Engineers Comments Regarding Surface Water Drainage

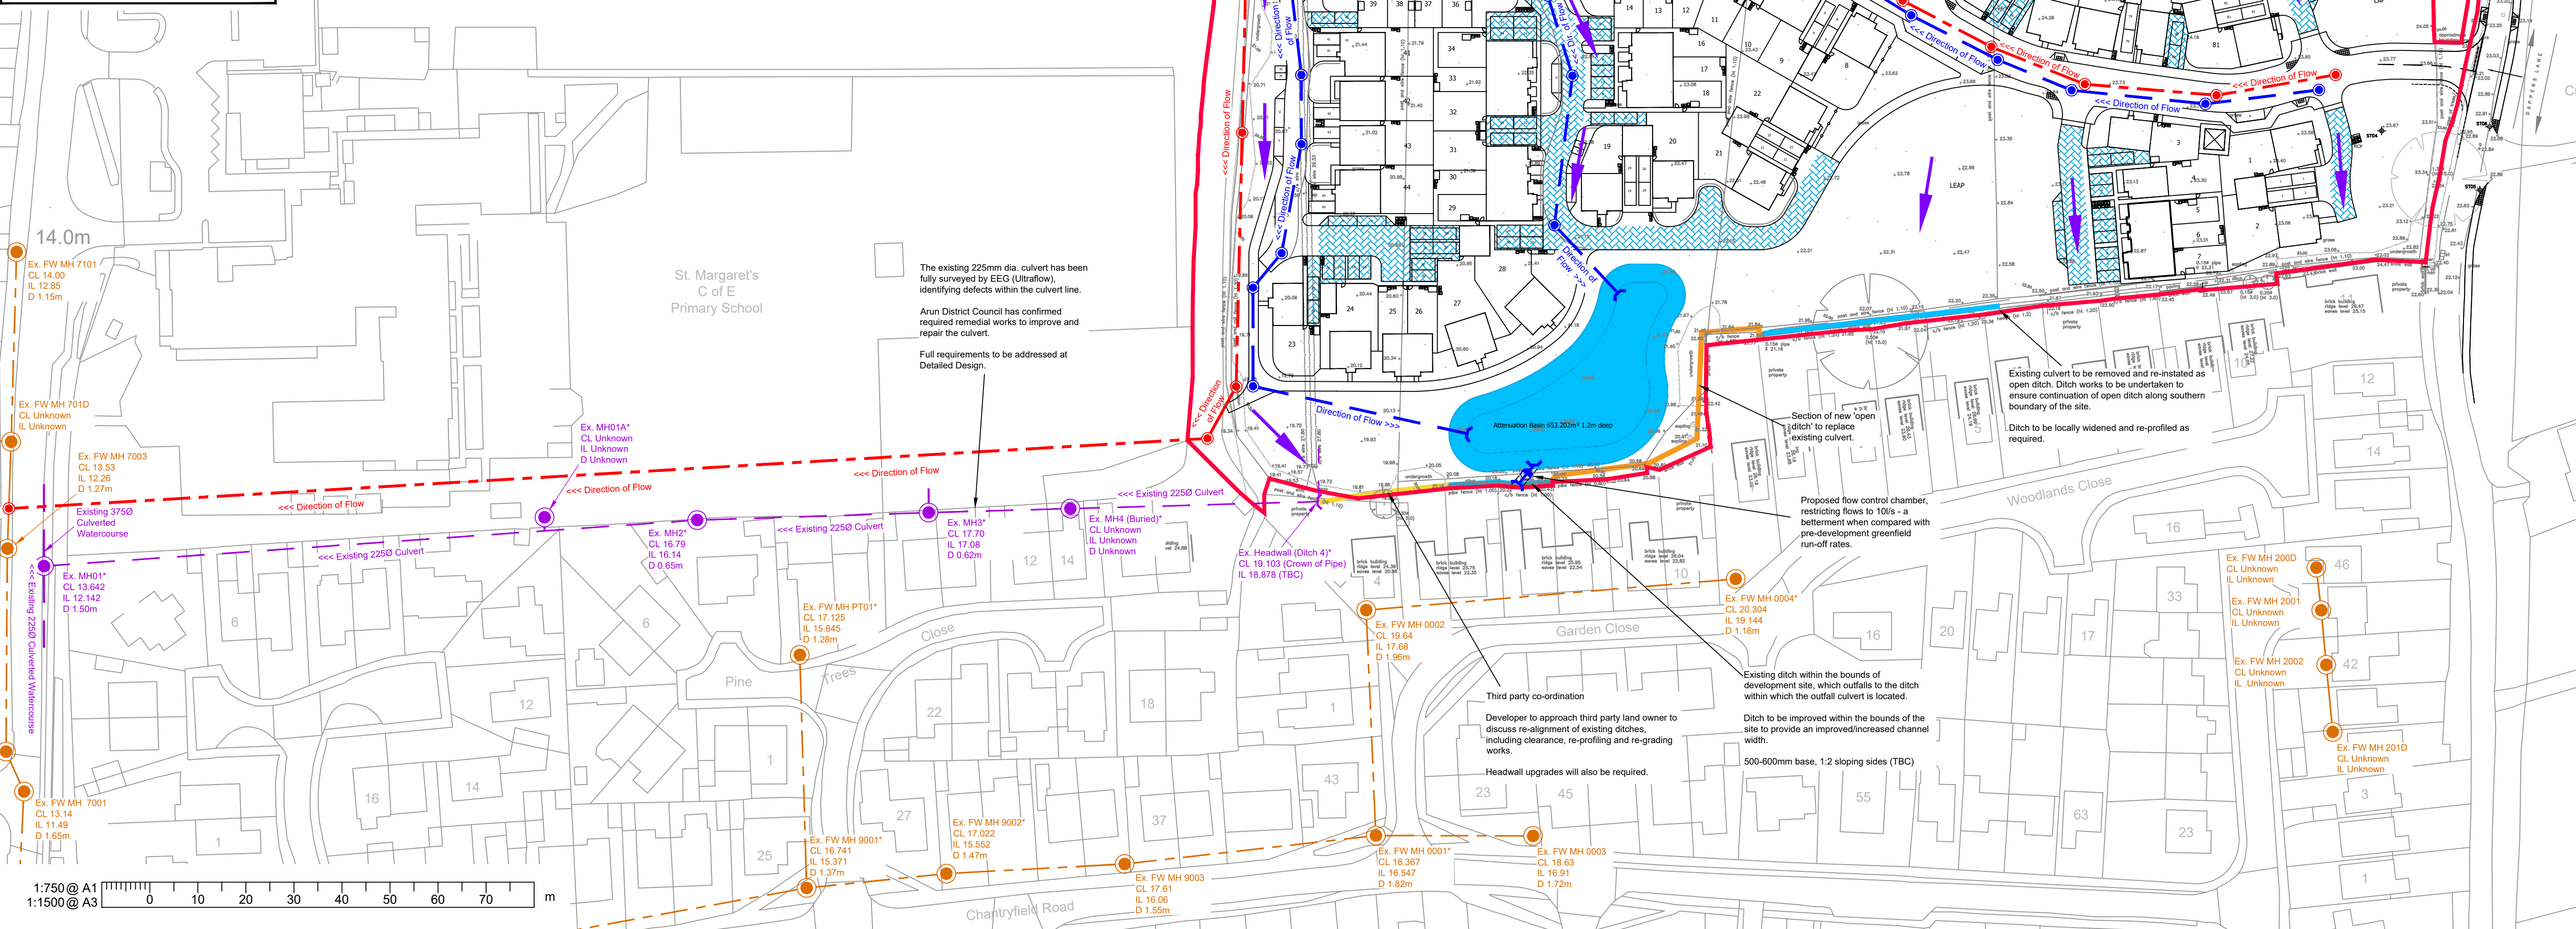
The proposal is for an attenuation basin and lined permeable paving to provide storage prior to discharge to watercourse or new surface water sewer. This is acceptable in principle as it follows the hierarchy for sustainable drainage, will provide adequate treatment, and provides wider benefits of SuDS such as amenity and biodiversity.

As the application seeks approval of a layout we request more details are provided at this time:

1. Catchment area plan to enable verification of provided calculations, preferably in dwg format.
2. Cross sections of attenuation basin, detailing offset of basin to surrounding features, including adjacent ordinary watercourse. An unobstructed 3m buffer should be provided around the attenuation basin.
3. Flotation calculations demonstrating that a safe basin design can be achieved in the given footprint and provide the required free volume for water storage.
4. Revisions to landscaping plans to move trees out of the attenuation basin- currently acers for example are proposed within the basin extents. This is not acceptable as the basin will have to be lined. Please ensure that all root potential areas are outside of surface water drainage feature extents.
